North Falls Offshore Wind Farm Ltd – EN010119

Section 51 advice regarding draft application documents submitted by North Falls Offshore Wind Farm Ltd

On 24 May 2024 North Falls Offshore Wind Farm Ltd submitted the following draft documents for review by the Planning Inspectorate as part of its Pre-application Service¹:

**NORTH FALLS**  
Offshore Wind Farm

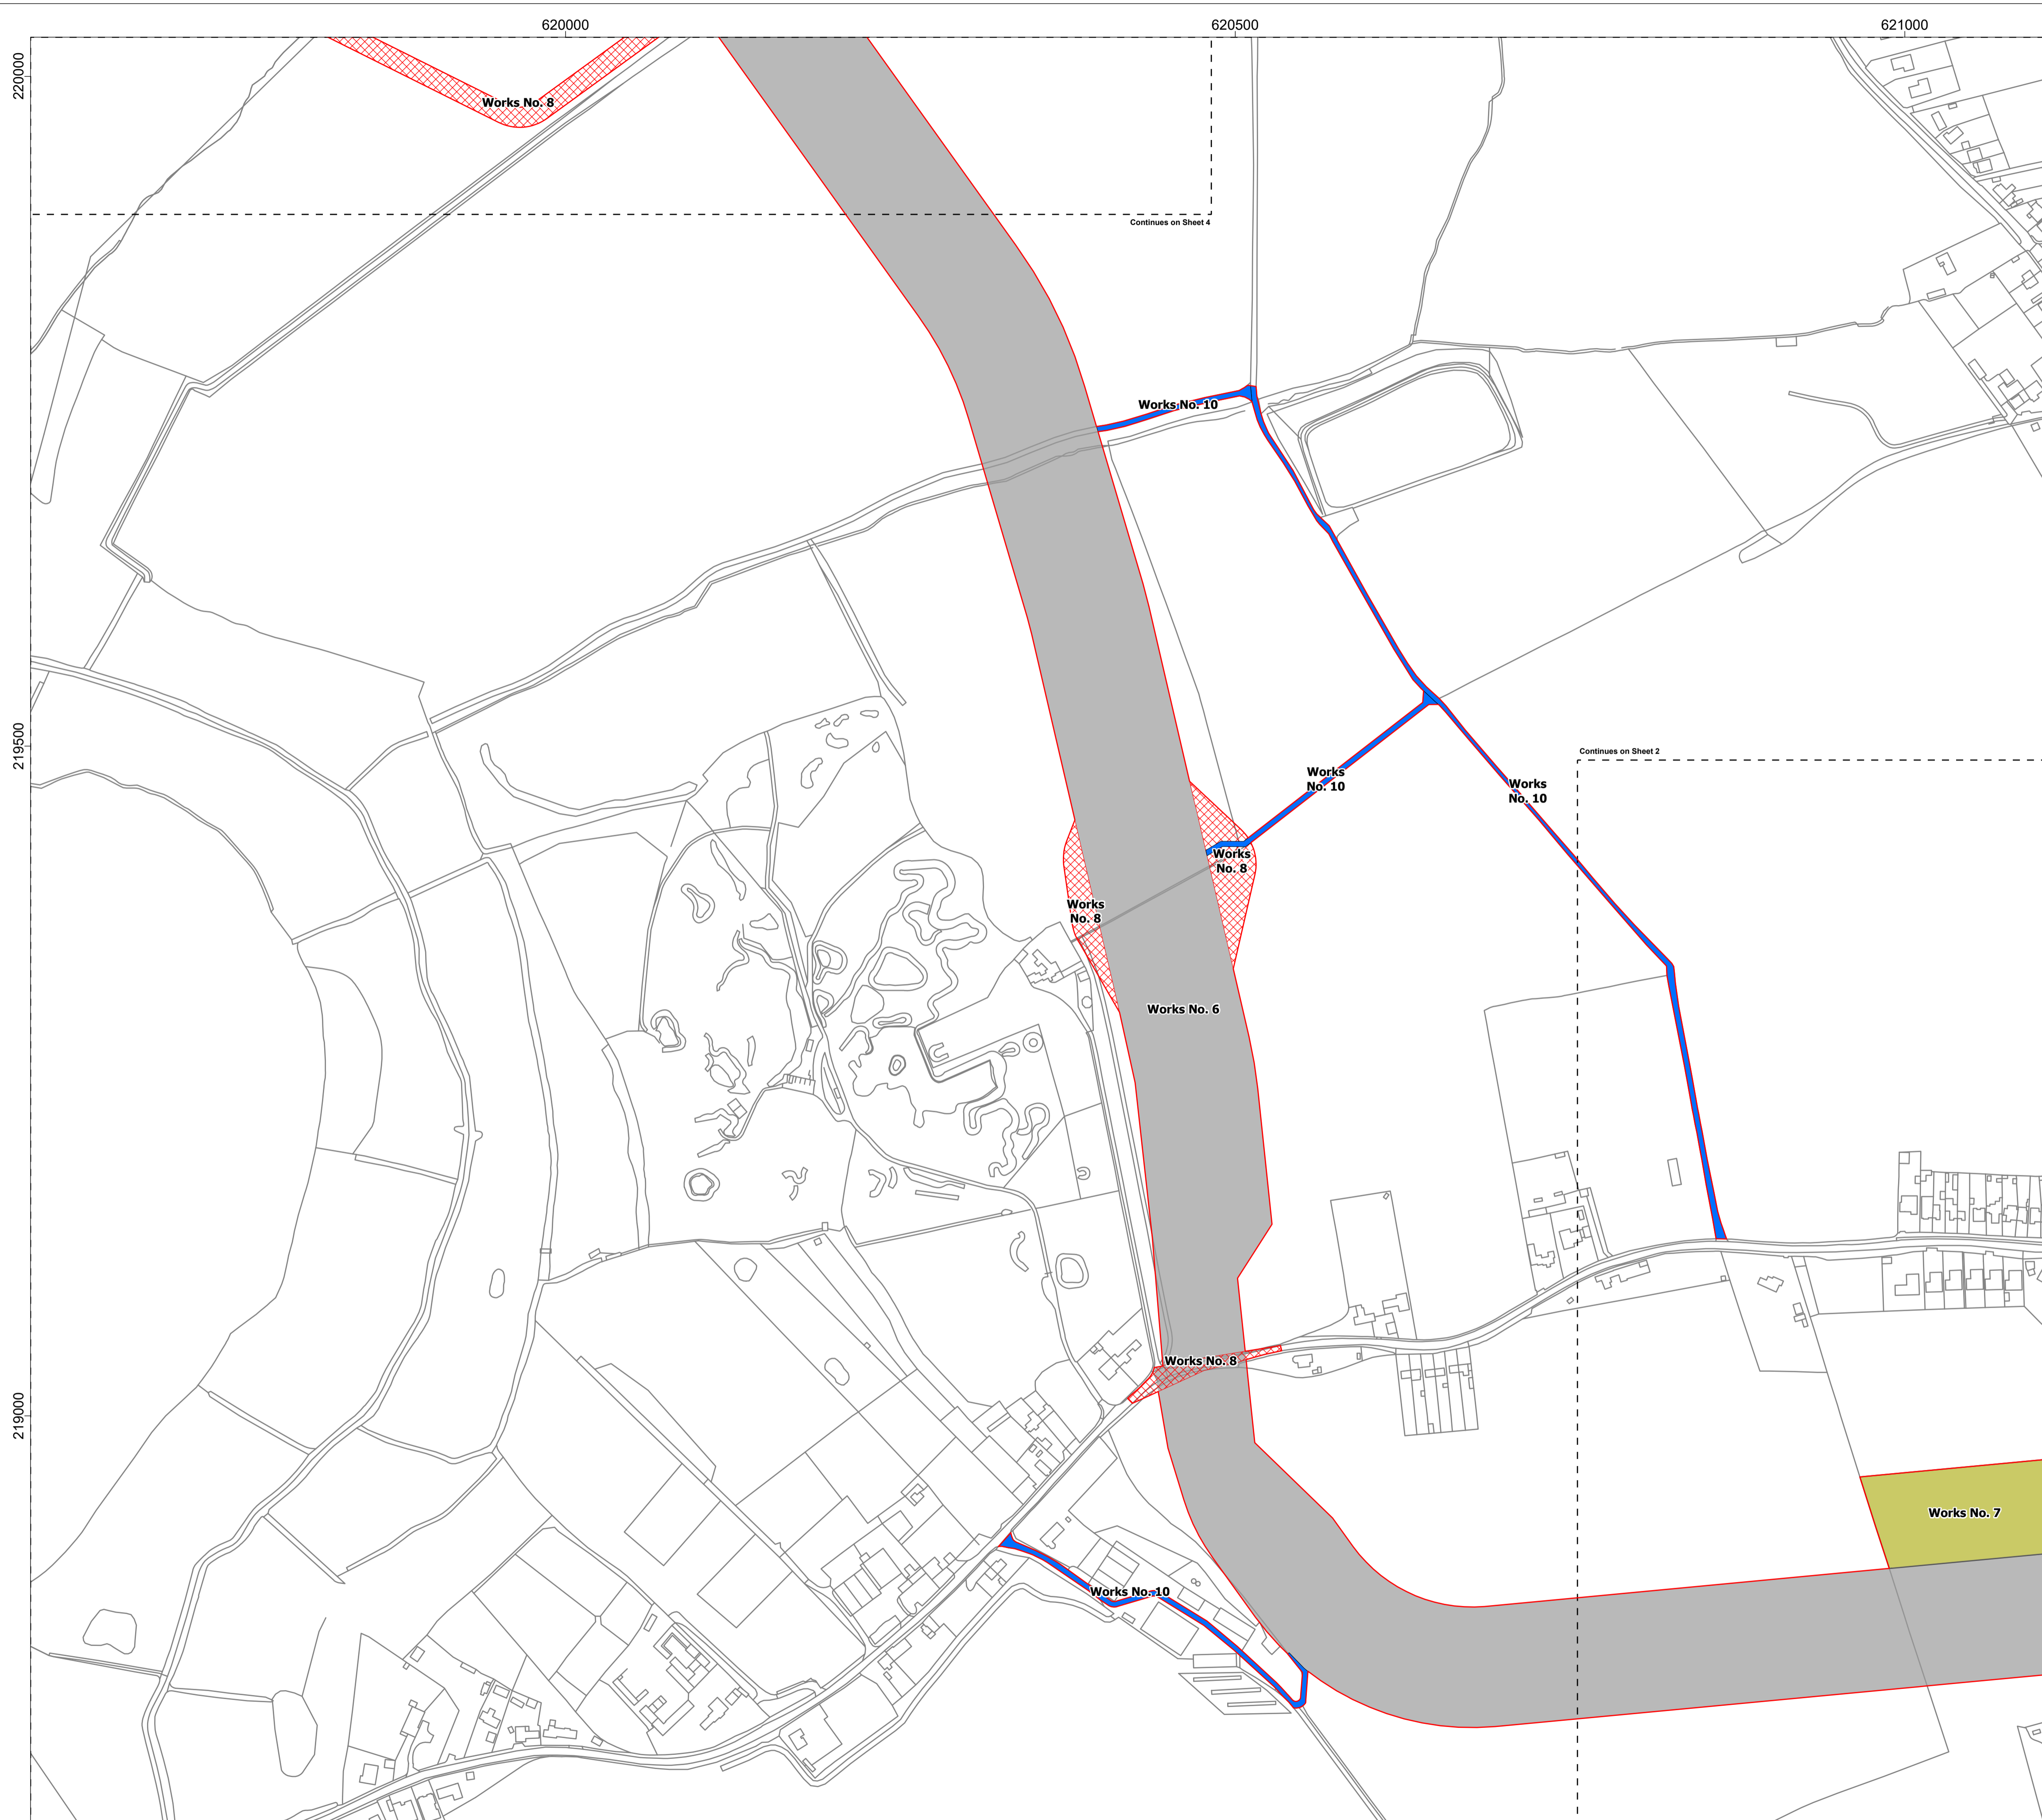
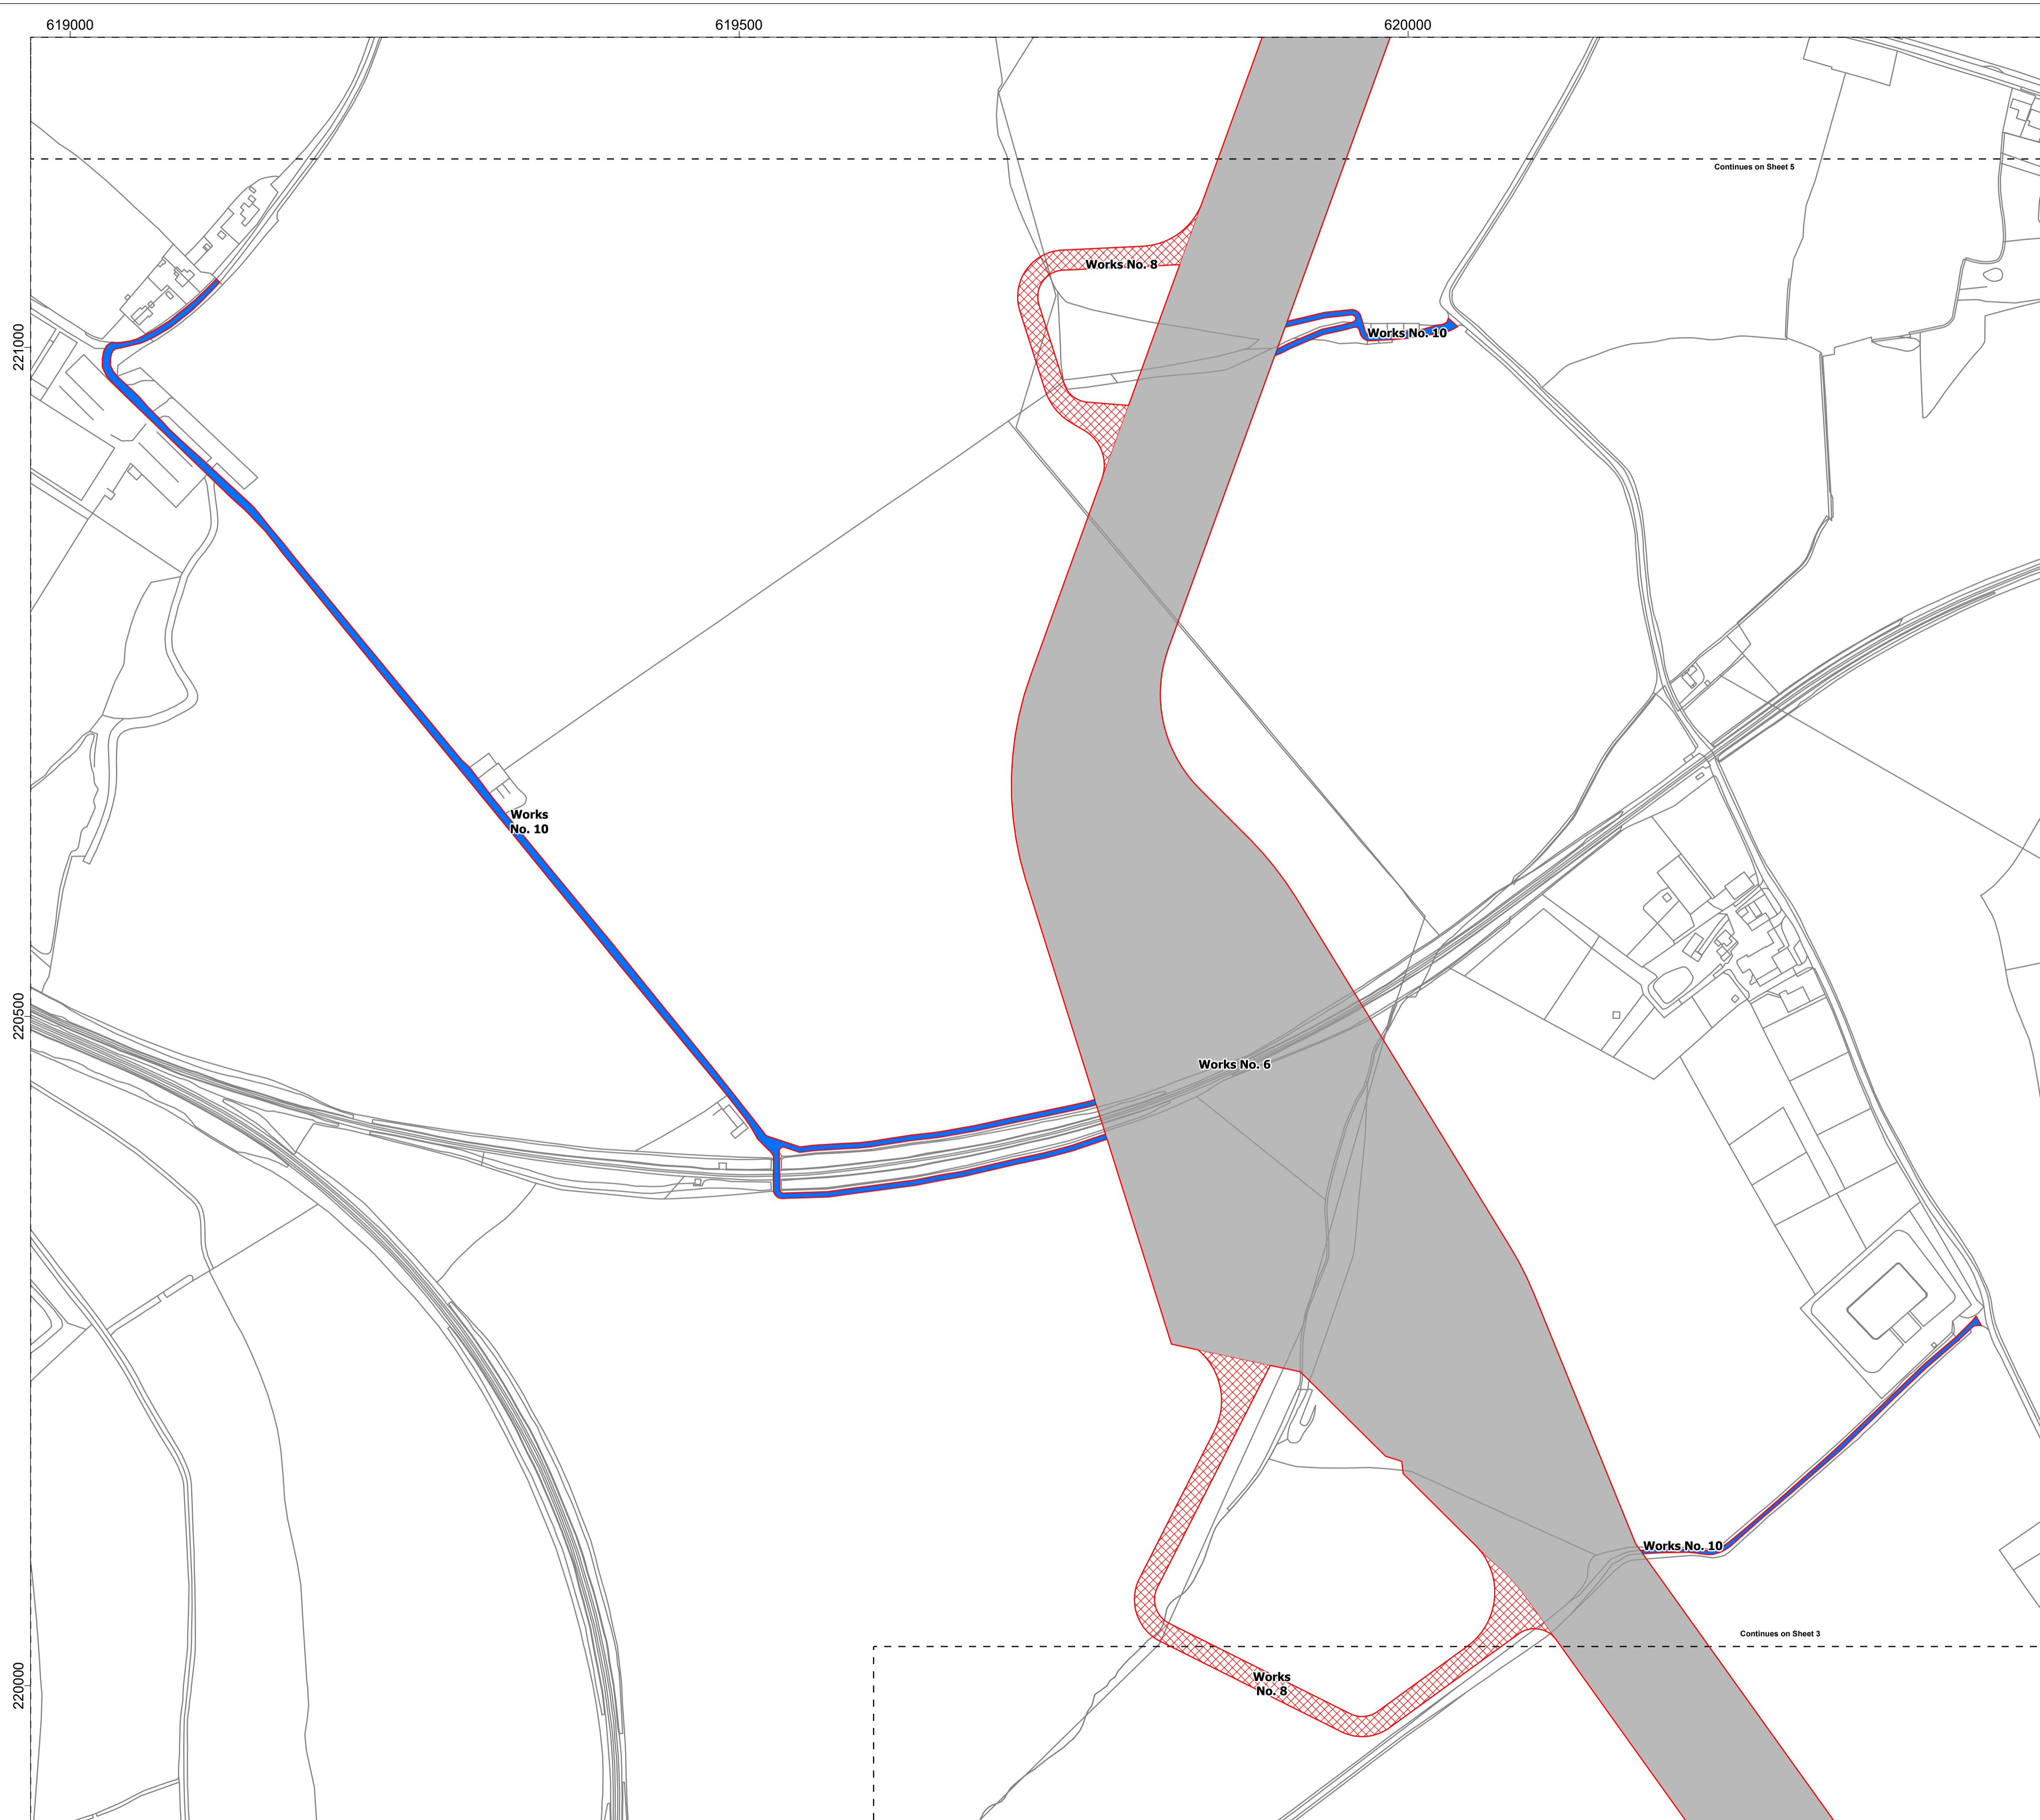
8.	Each sheet contains all Work numbers even when that work does not appear on the sheet. The Applicant could consider whether this is confusing to the user. Eg 4d is on Legend for all sheets but is not present on all of them

9.	The Legend states, 'Works numbers' and the dDCO refers to Works numbers, but the references in the plots start with 'WP' and not 'WN'. The Applicant may wish to consider renaming the Works numbers to make it clear that the ref is to the Work number within the dDCO and not a Work Plan.

Onshore plans		
Ref.	Plan ref	Comment or question
12.		The Works Plans do not contain any identifying information, such as village or road names, which the public may wish to use to identify their properties, land or other areas of interest.
